28th December 2017

M/119/17/PL Variation of condition No.2 imposed under M/75/17/PL and M/121/17/Doc Approval of details reserved by conditions imposed on planning reference M/75/17/PL....

*proposed block plan*

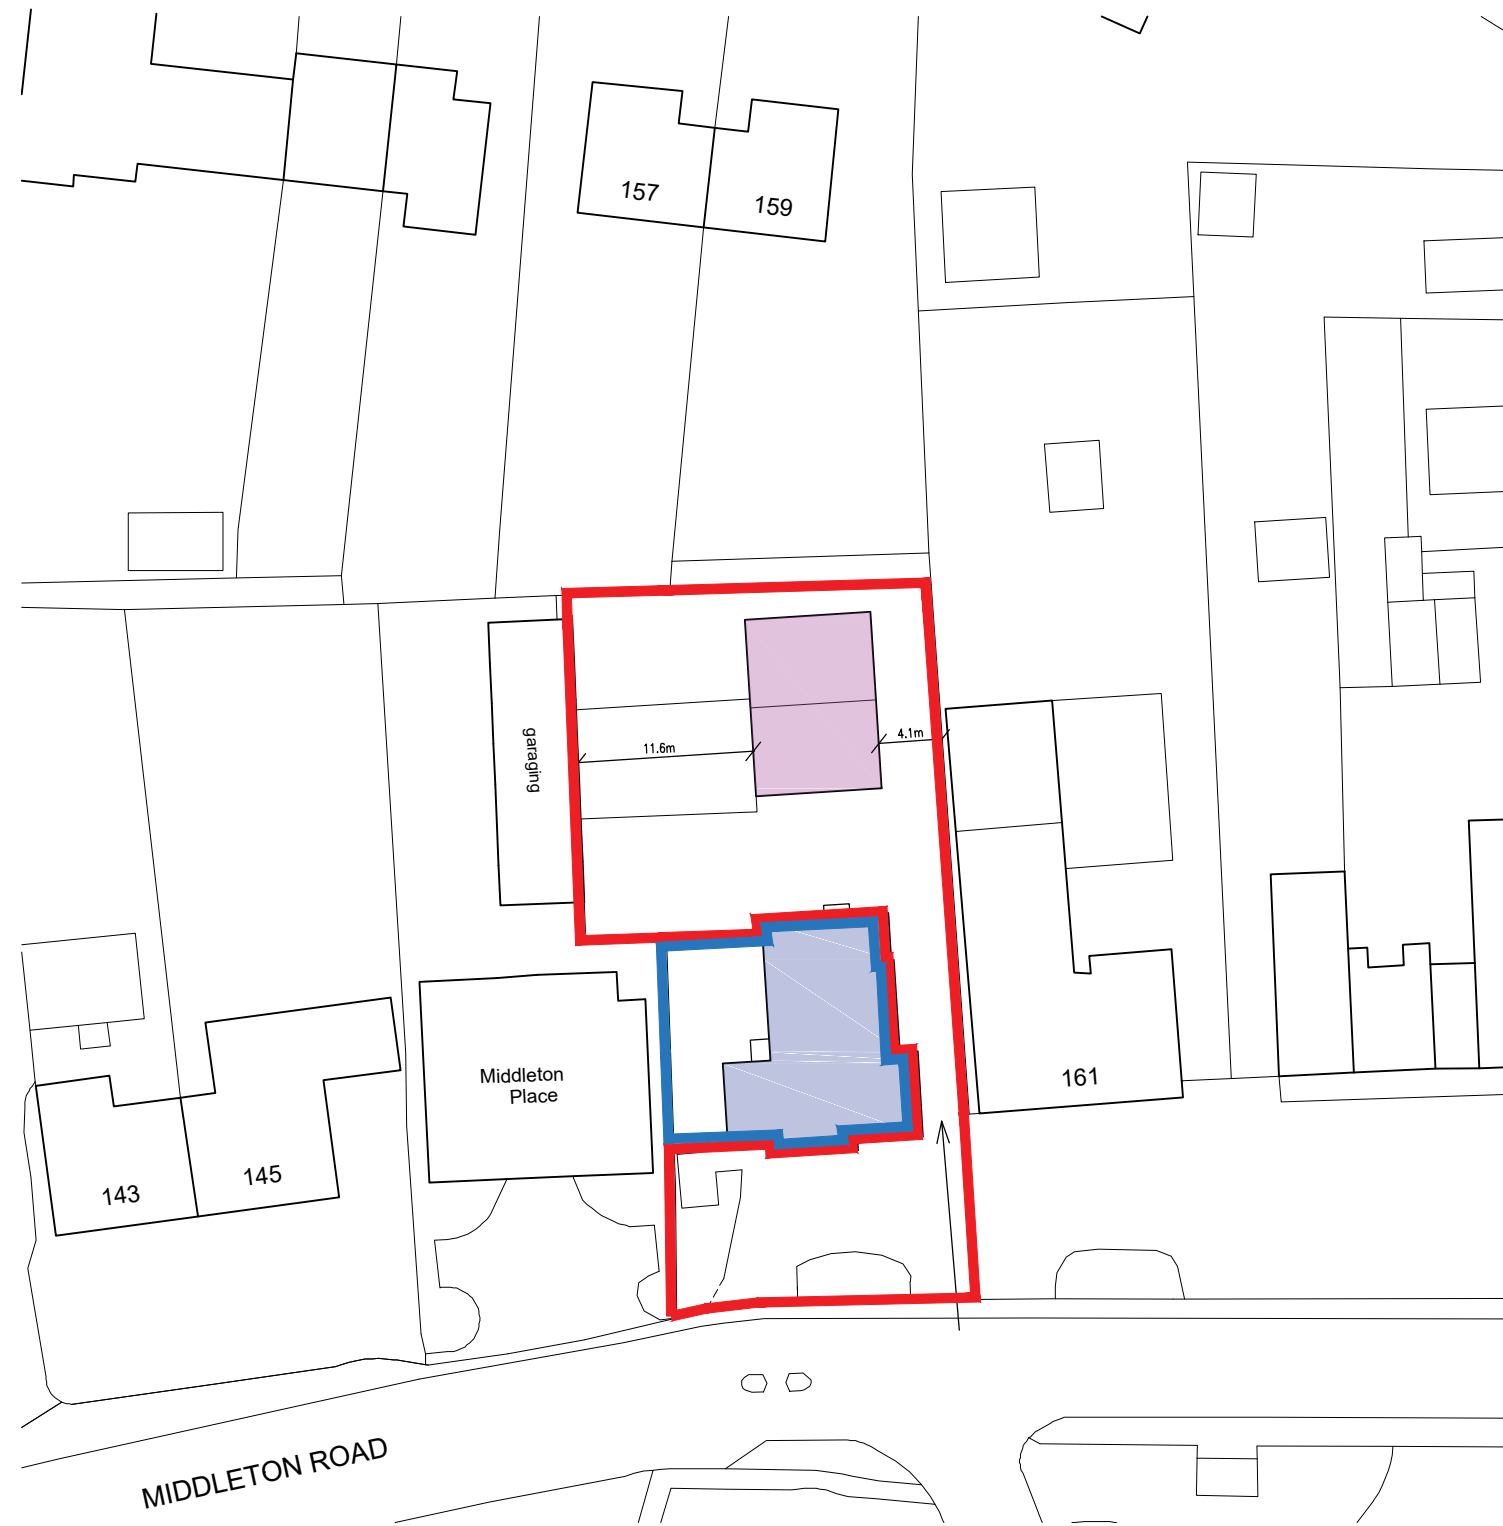
- 1 x 1 Bedroom apartment created at rear of Retail Unit – Parking provision of 1 space
- 1 x 2 Bedroom apartment created at rear of Retail Unit – Parking provision of 1 space
- 2 x 2 bedroom Chalet - Parking provision of 2 spaces for each

It is apparent that further parking provision (1 additional per town house) is required to cater for the occupants of the additional bedrooms now proposed.

"Access to 157 & 159 Middleton Road - Access to 157 & 159 Middleton Road is provided via a private footpath leading from Middleton Road along the eastern boundary of the applicant's site."

The Planning Authority has been made aware of this "right of way" and continues to approve plans submitted by the applicant that are in breach of the applicant's legal obligations. For the avoidance of doubt "The passage four feet wide on the Eastern side of the land in this title (WSX119494) is subject to a right of way". The submitted plans show a pathway that is considerably narrower than four feet (roughly 2' 9") and we note that the applicant is seeking approval for drainage and civil arrangements based on this reduced width of path. Also, the note on DRG FC2705/03 that "Path gradient/steps tba onsite with B Control" indicates the needs and wishes of the beneficiaries of the right of way have been ignored. The "right of way" must be provided as per the property deeds and be capable of accommodating children's prams and mobility scooters for the elderly.

Other than vague verbal statements made that confirm a right of way will be retained no consultation regarding the details has been made with us. It would therefore seem premature to approve a scheme that neither satisfies nor replicates existing arrangements, has not benefitted from consultation with affected parties and is in breach of legal obligations relating to the site. Perhaps you could encourage the applicant to consult with their neighbours so as to avoid the possibility of more serious intervention.

*proposed front/east elevation*

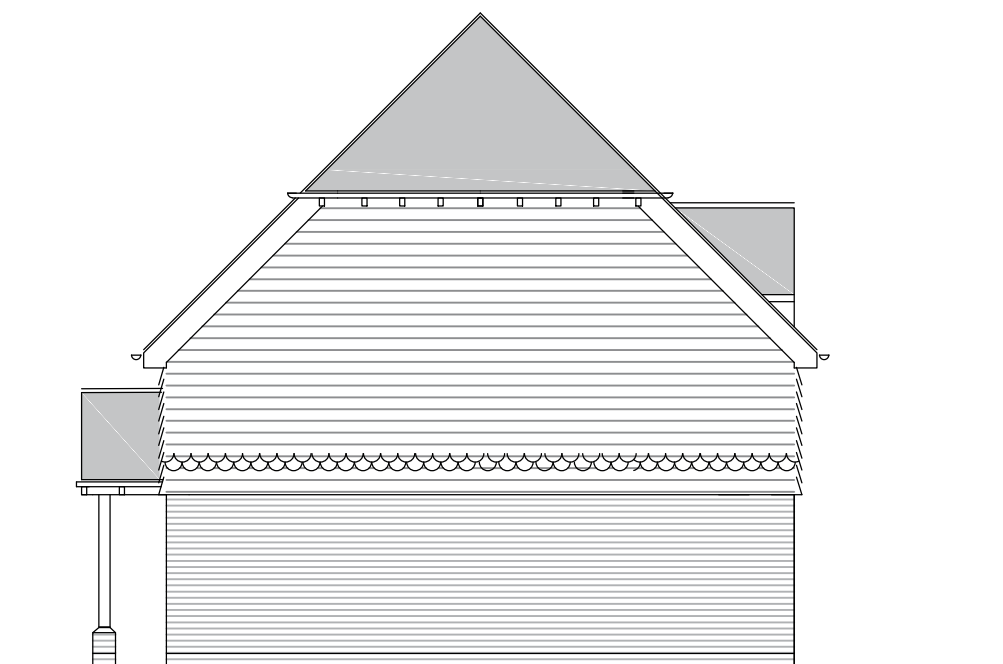
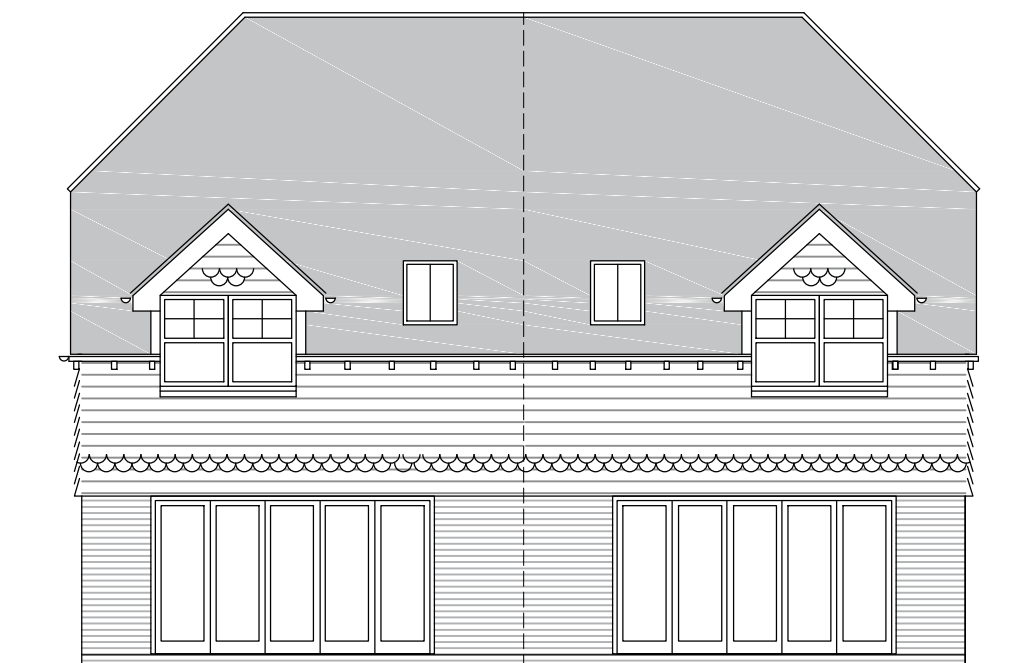
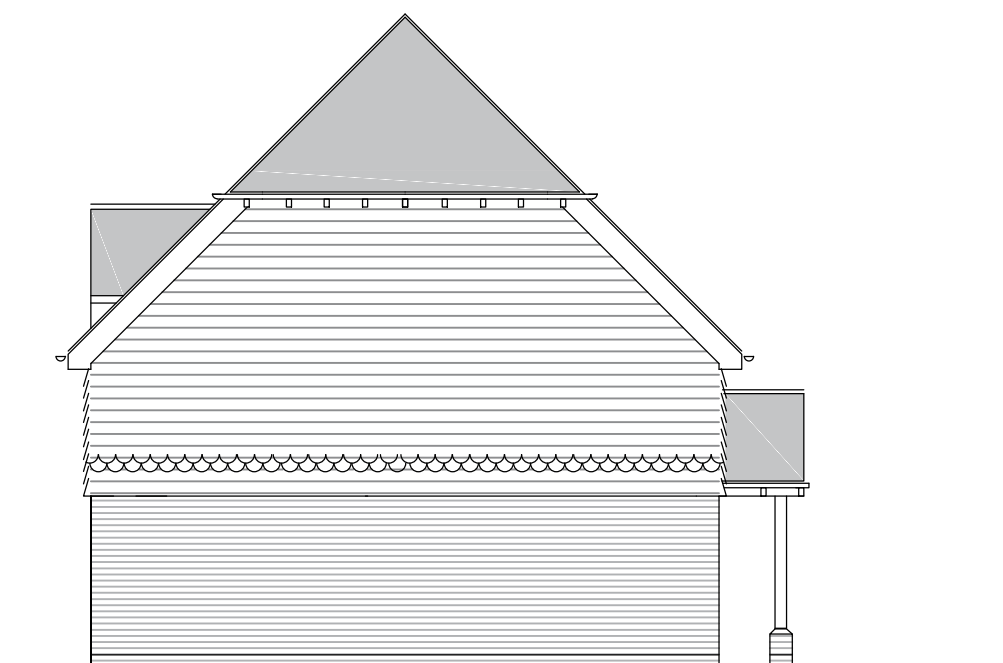
"Detached Chalet Bungalow to Rear - The sheer size and scale of this building detracts from the visual amenity currently enjoyed by 157 & 159 Middleton Road. The roofline ridge height of 8.3m is at least 2m higher than either the existing building at 155 Middleton Road and both of 157 & 159 Middleton Road."

It is obvious that the applicant set out consistently to game the planning system so as to arrive at a development that started out as a "chalet bungalow" and has morphed into a pair of 3 story townhouses creating a site with a potential occupancy of 18 people where 4 were accommodated previously. This density increase is our principal cause of concern together with the associated impacts on the amenity value of our home. Parking is clearly also an issue with the Planning Authority applying different rules for different parts of the site:
